TO: *Hearing Examiner, Rose Shriner, CDS*
RE: *BCT (Big Creek Trails)*
Date: *July 14, 2016*
FROM: Roger B. Olsen
2130 Nelson Siding Road
Cle Elum, WA. 98922
(509) 674-3881

I have some specific comments regarding this rezone and project. My resources are the applicant's submitted paperwork, Kittitas Counties Comprehensive Plan and the GMA (growth management act).

RZ-15-00001

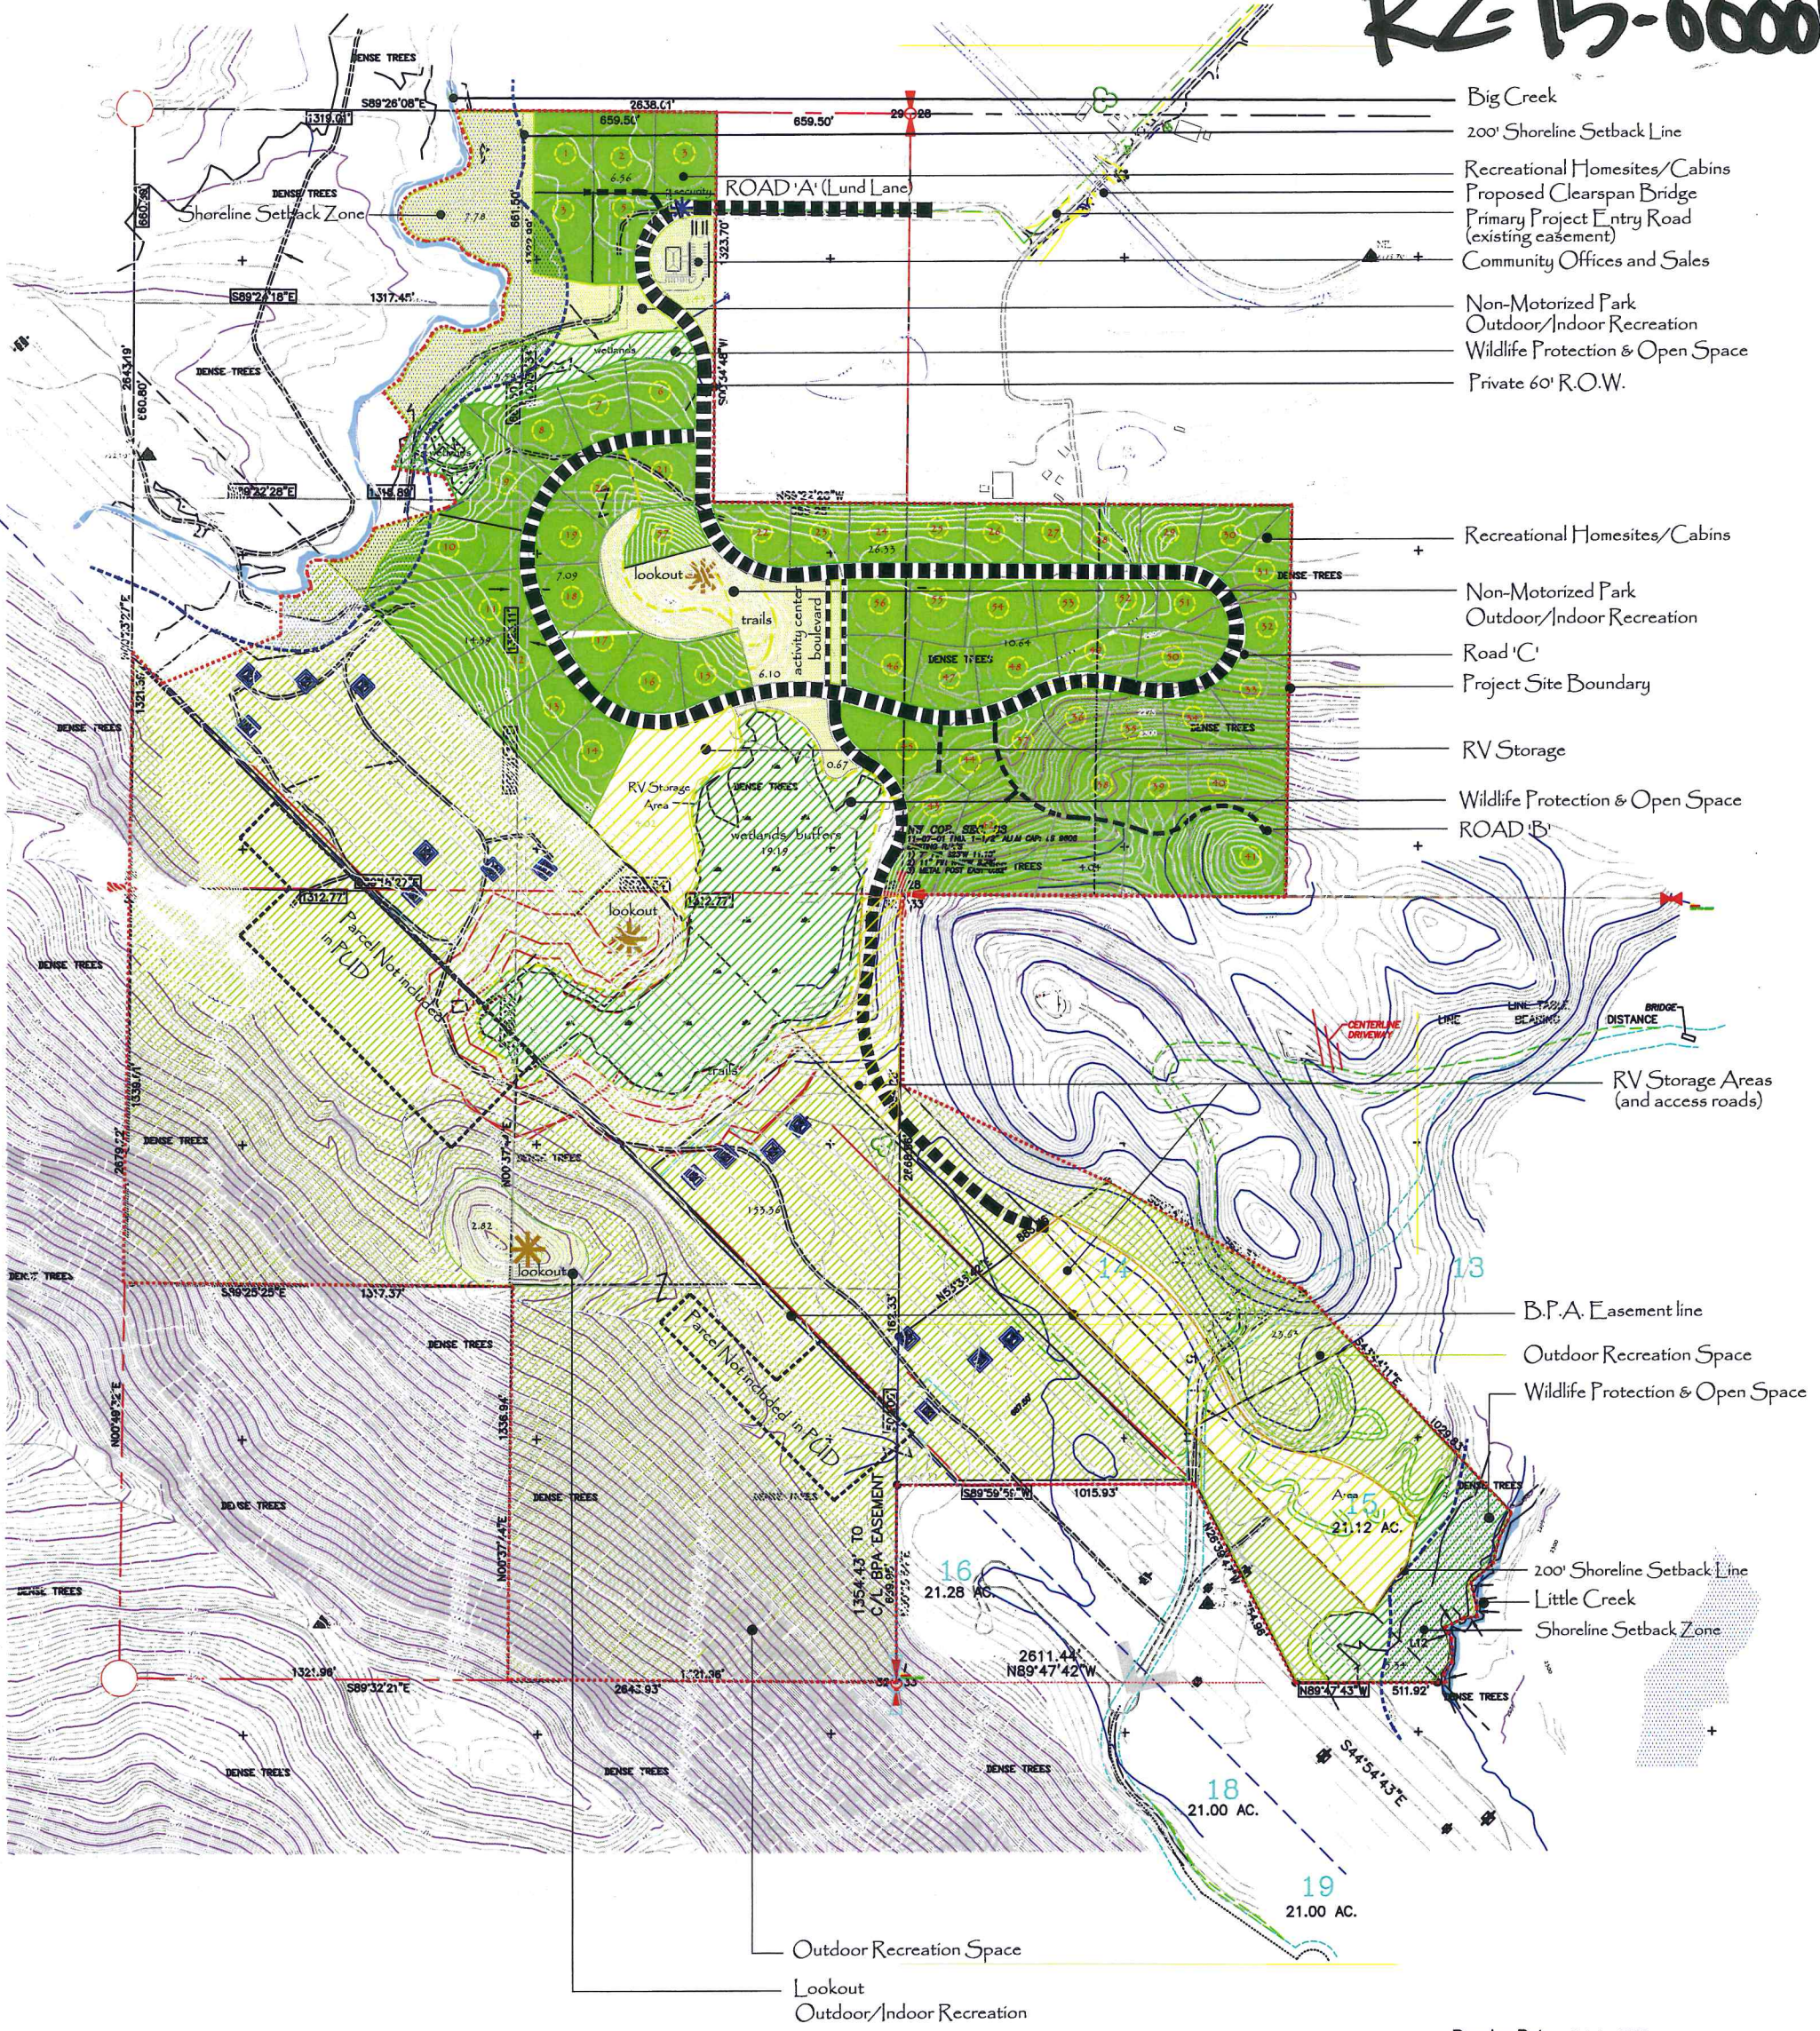
There are 57 proposed homes on 92.7 acres according to the BCT concept map. One parcel is 21 acres not cluster with the remaining 56. Those 56 remaining lot are clustered on 72 acres resulting in an average of 1 du/1.28 acres. BCT contains low density sprawl, which does not protect rural character. Nothing prevents the continuation of this 57 lot cluster from being in close proximity to or adjacent to another 50, 100 or 200 lot cluster of homes in another PUD.

According to the BCT concept map, 126.8 acres is “Outdoor Recreation Space”. This area consists of mostly steep slopes. BCT adds no added benefit to that land, the project or the public.

The Wildlife Protection and Open Space designation of 28.1 acres consists of wetlands and buffers near Big Creek and Little Creek. Again BCT adds no added benefits that don’t already exist.

The developer doesn’t say how much land is under the power lines or how much of this project is subject to the BPA easement and right of way but it is substantial. Take away already protect land and there is not much more that the 92.7 acres left. This project basically takes the 92.7 acres that can be used and gets credit for 285 acres.

This project is big enough to require a 2nd access road but I see none in the proposal other than at some time in the future Fowler Creek to Nelson Siding Road corridor is completed but that may never happen. In the interest of public health, safety and welfare, a second access should be required before project approval. I can tell you sprinkler systems are no substitute for a second way out of a dangerous wildfire situation.
